**The Able Marine Energy Park Development Consent
(Amendment) Order 2022**

Made - - - - *16th July 2022*

This Order amends the Able Marine Energy Park Development Consent Order 2014 (“the 2014 Order”), a development consent order under the Planning Act 2008 (“the Act”).

**Works Plan - Key Plan**

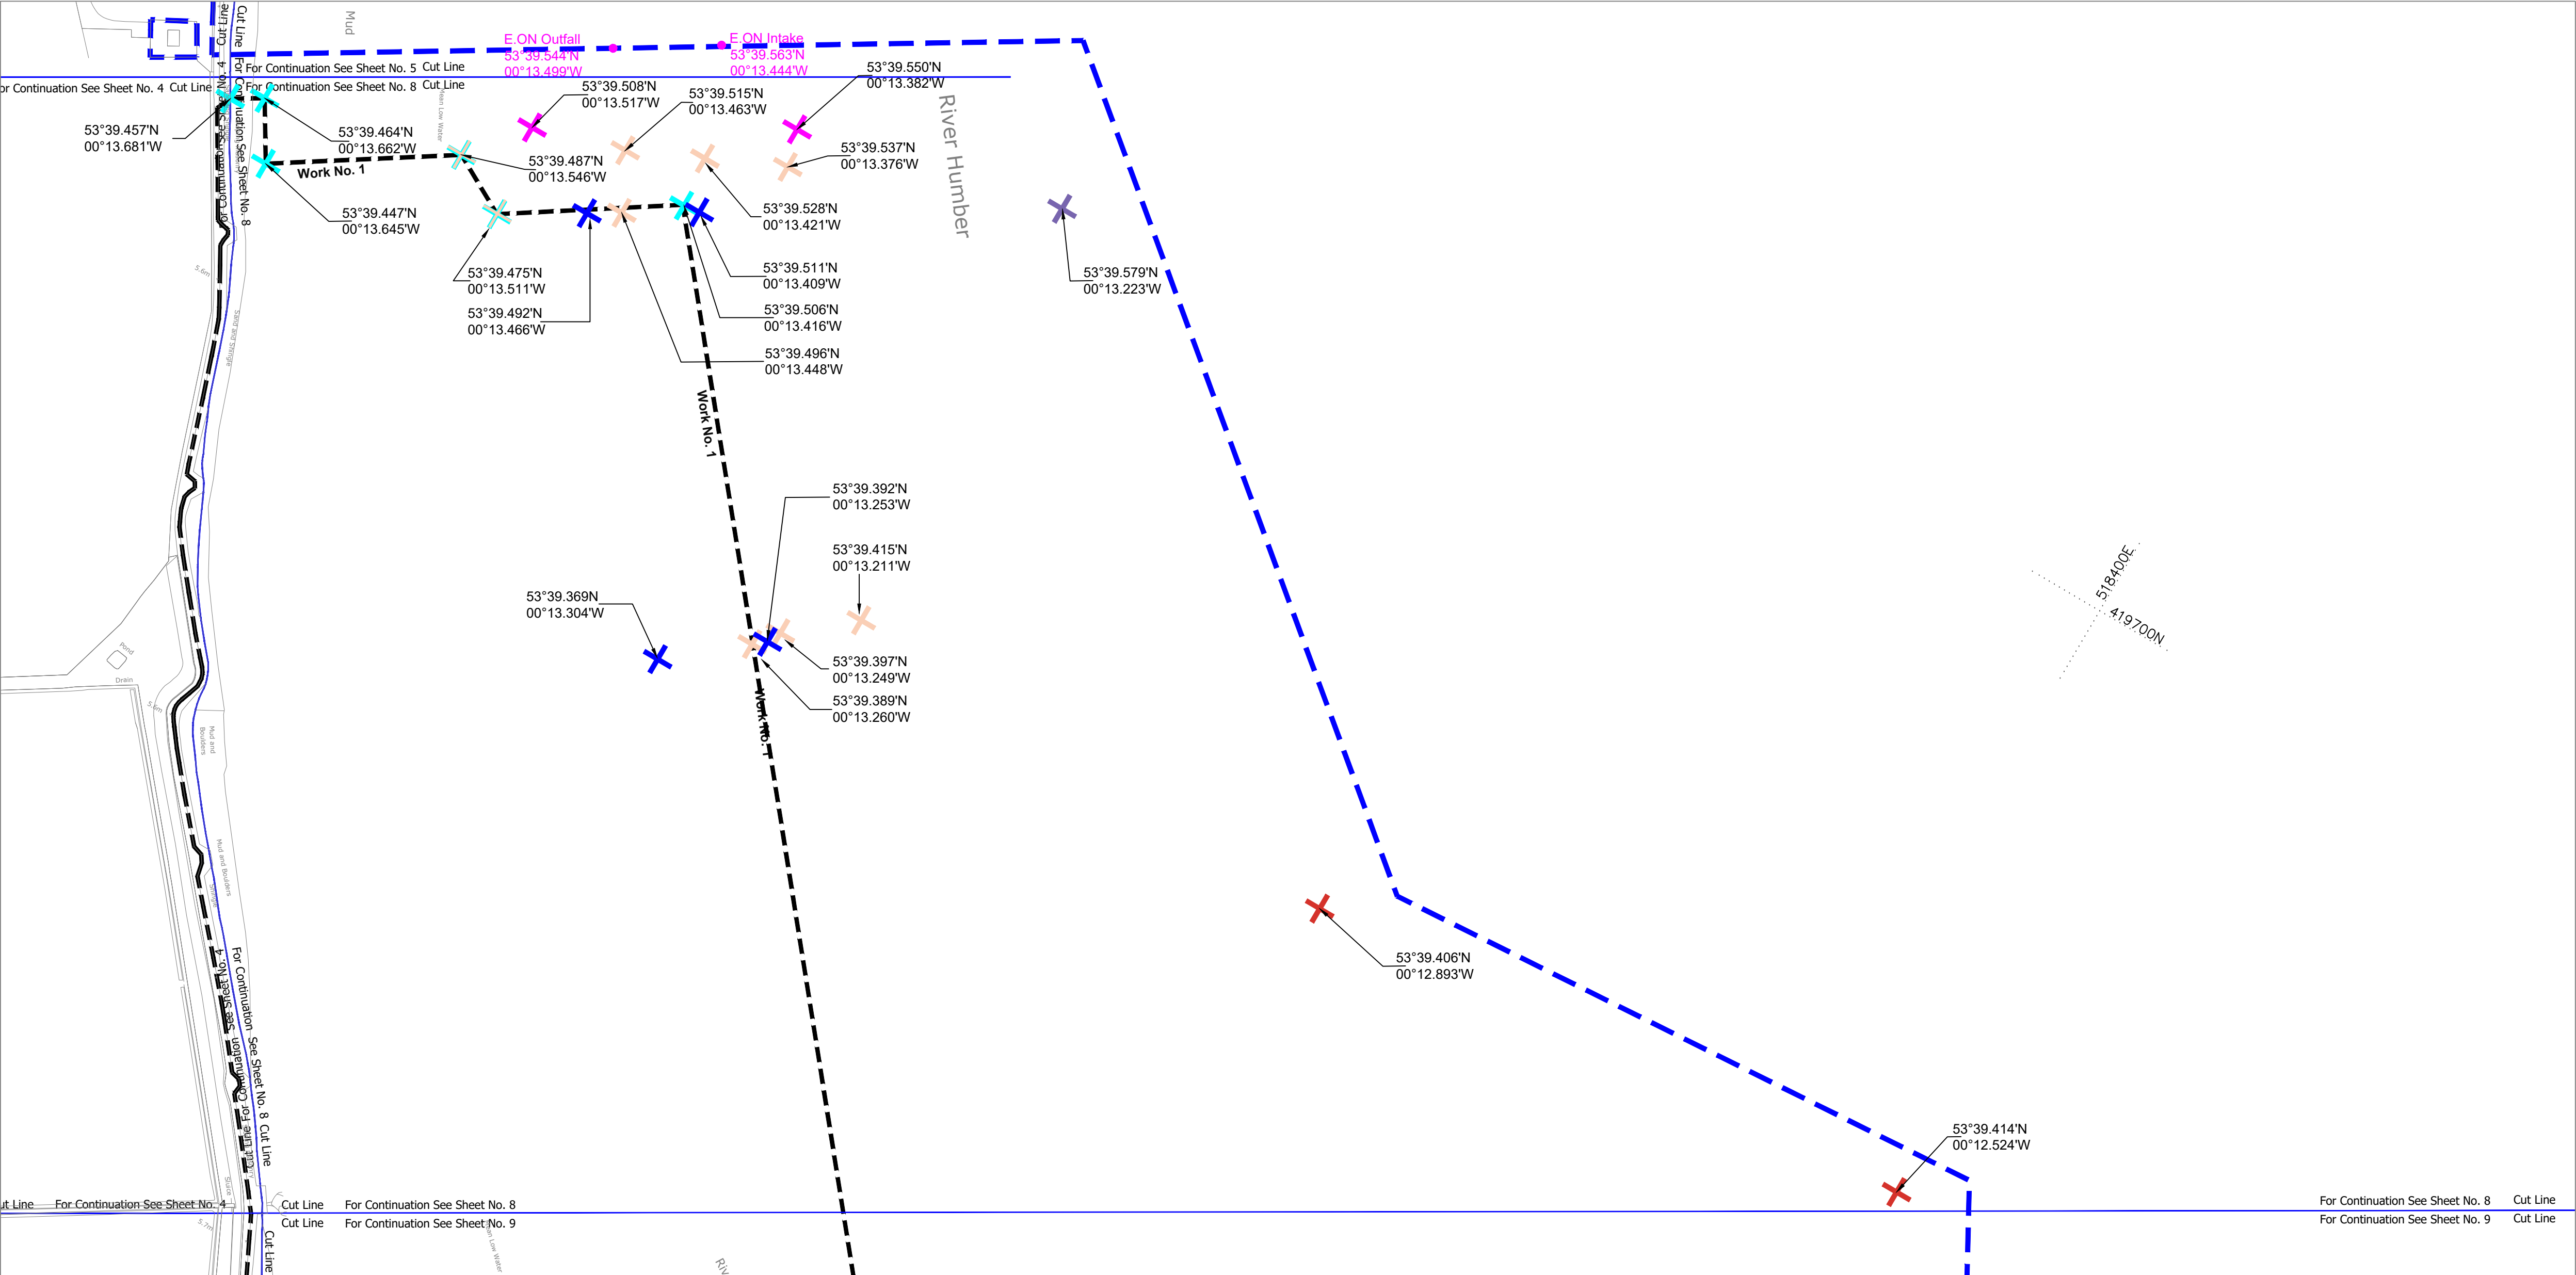
“the inset berth” means the area bounded by co-ordinates (53°39.492'N, 00°13.466'W), (53°39.511'N, 00°13.409'W), (53°39.392'N, 00°13.253'W) and (53°39.369'N, 00°13.304'W) and shown on sheets 8 and 9 of the works plans;”.
